Your Ref: OWPC17564
Our Ref: M/133/17/PL 01-12-2017
Please ask for:
Mrs A Gardner

Demolition & erection of 1 No. dwelling to existing ground floor slab.
Little Thatch 93 Middleton Road Middleton on Sea

Thank you for your internet representation made on 11th March 2018 which has been recorded as '**an objection**' with the comments as follows:

DRC N°: AB: 100 12

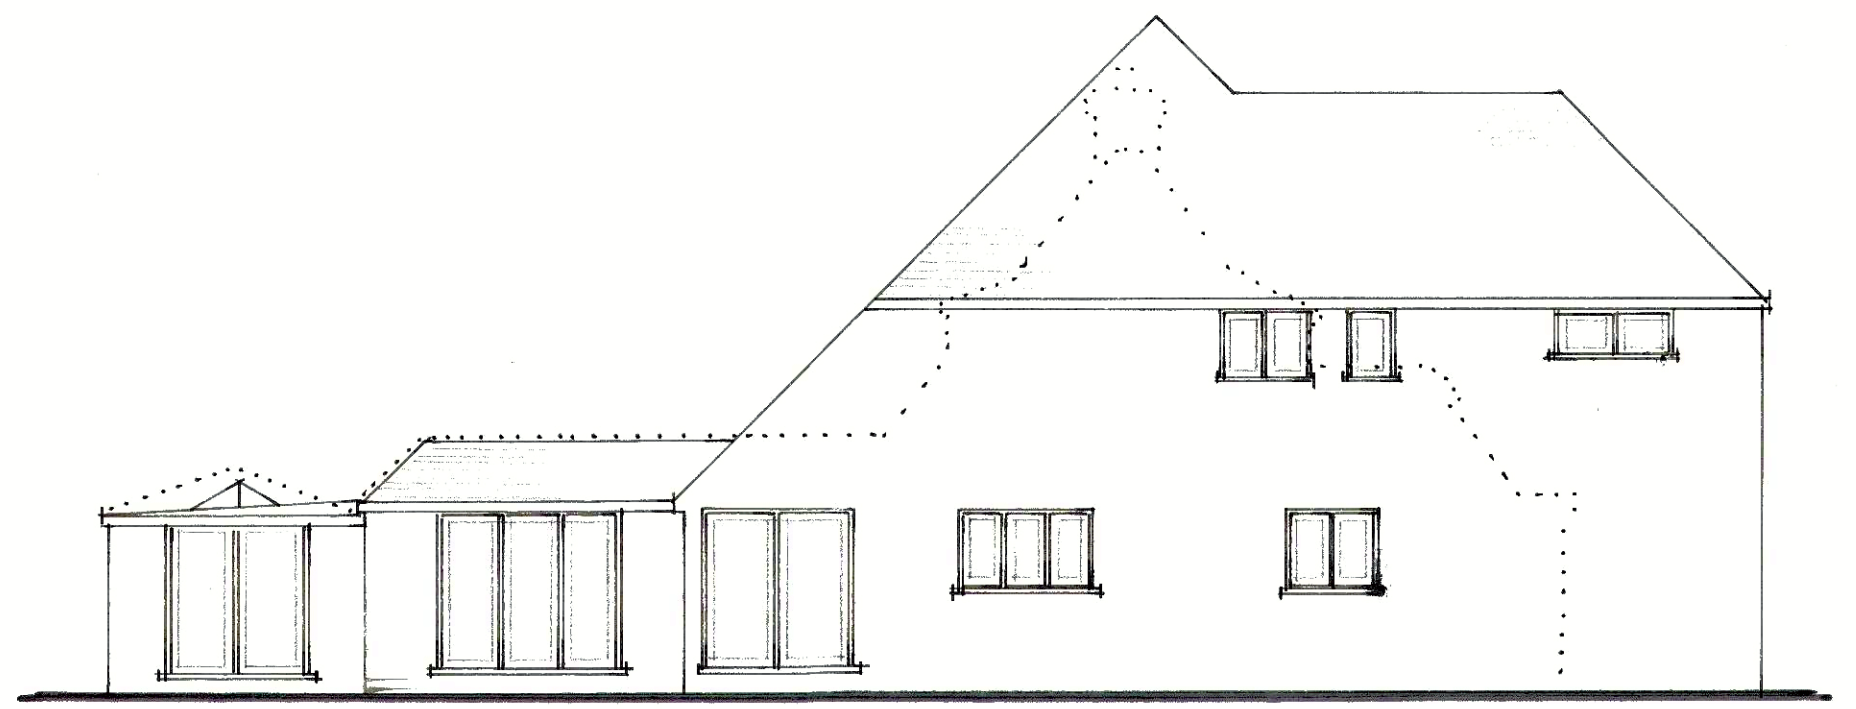
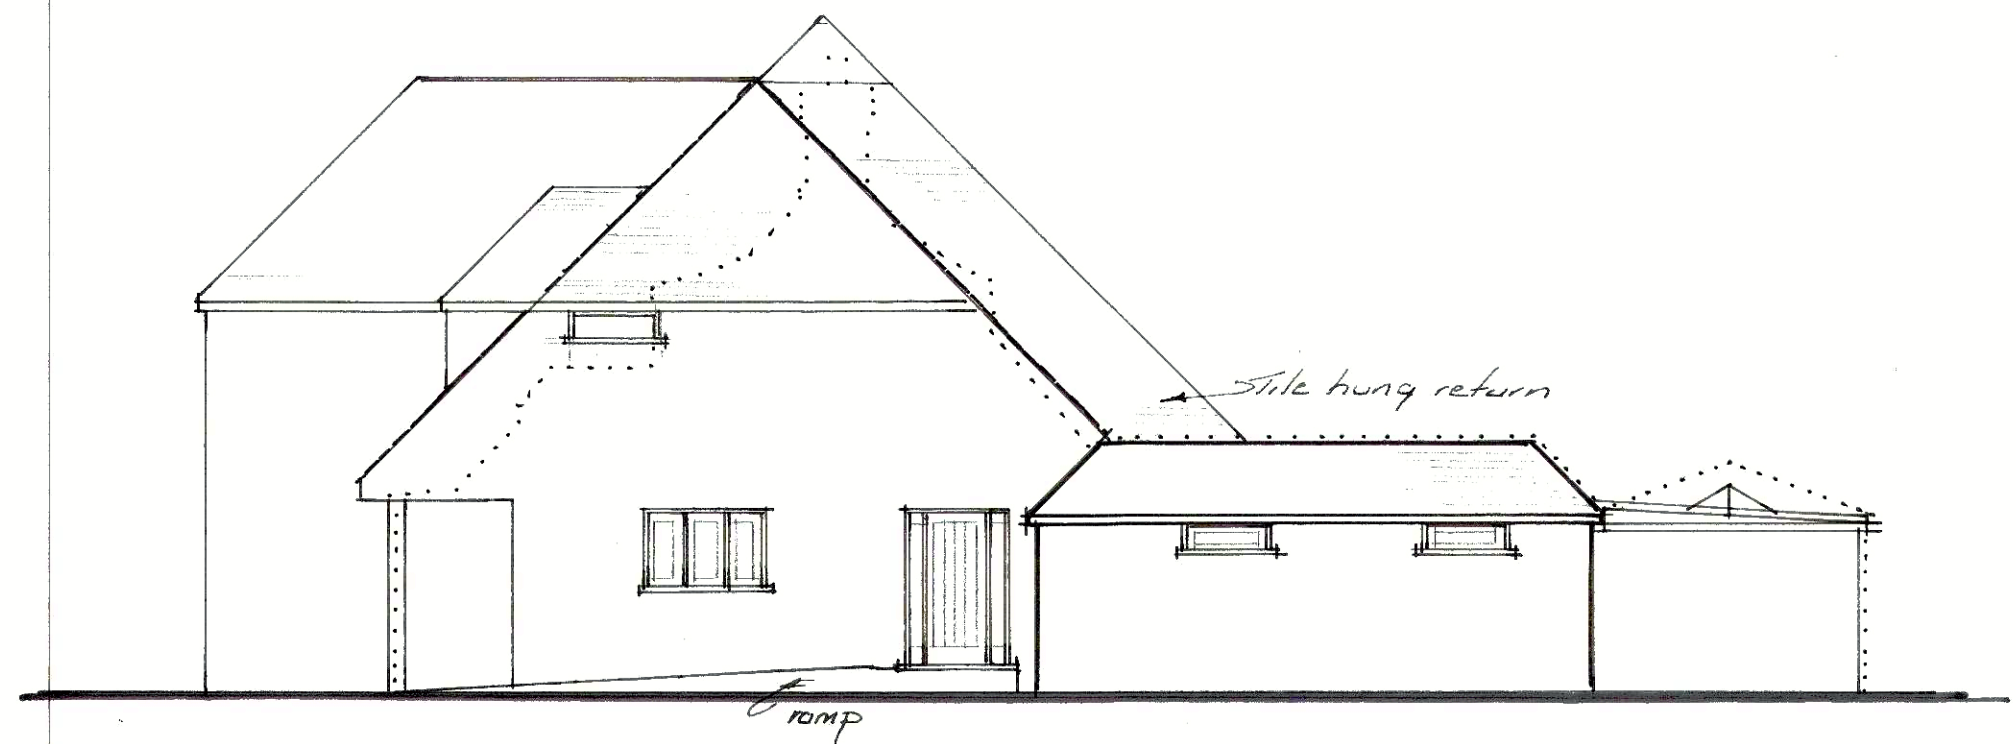
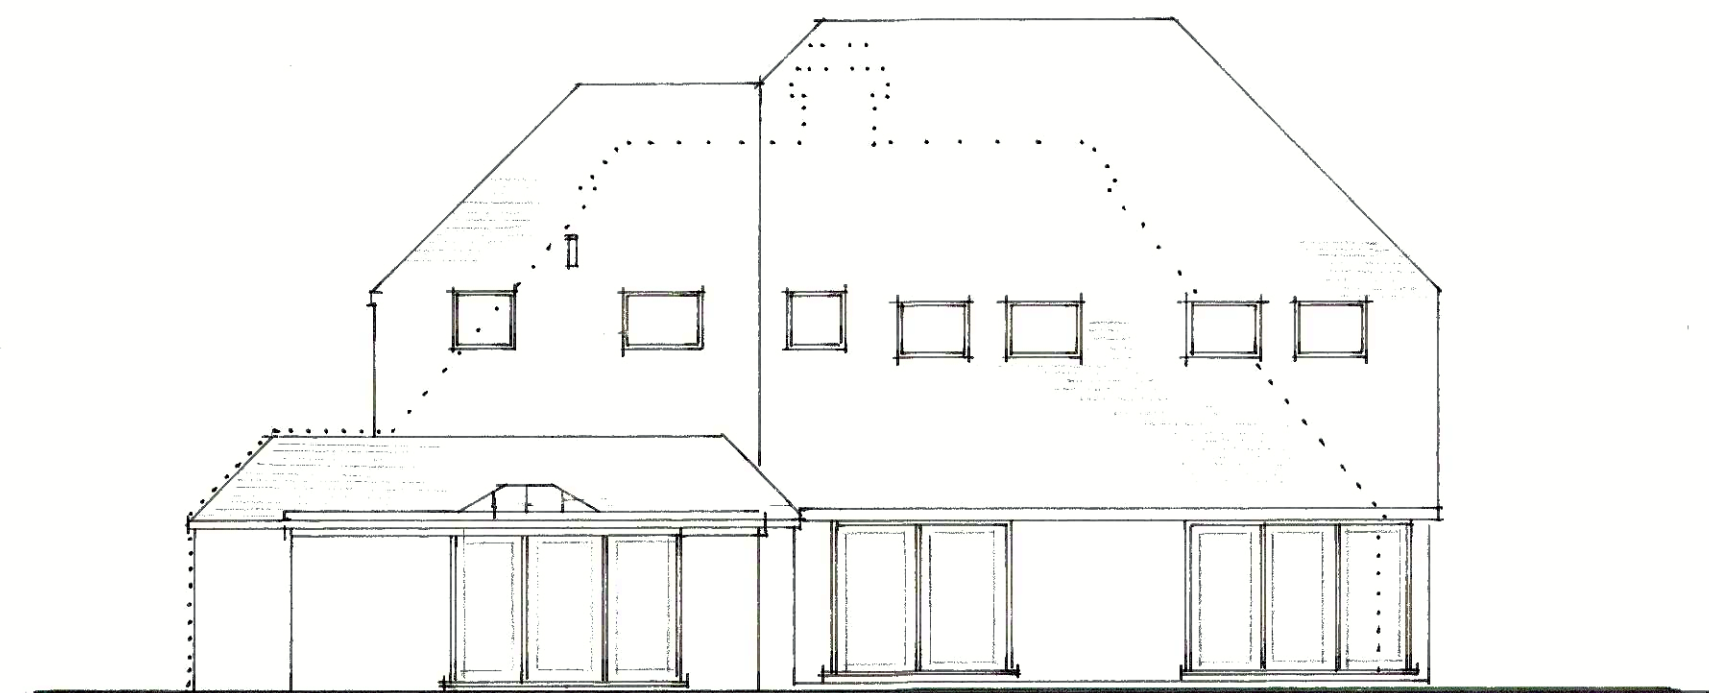
- the unusual set back of no. 93 (which results in the building running along the length of our rear garden)*
- its position so close to the eastern boundary*
- the substantial size and independent nature of the annexe and*
- the existing low eaves along with the lack of any first floor window or ground floor door on the east elevation.*

The two-storey house that would be created would have an over-bearing presence on us, resulting in a loss of amenity, including privacy, outlook and light levels. In our opinion the revised scheme continues to be inappropriate in its scale, positioning and design.

Without prejudice to our objections above, should the Application be approved we would like to repeat our earlier request for a number of conditions to be imposed. In addition, no glazing should be added in the future to the eastern elevation (wall or roofslope) of the front projection. Nor should any additional doors be added to the annexe (including the conversion of the study and utility windows).
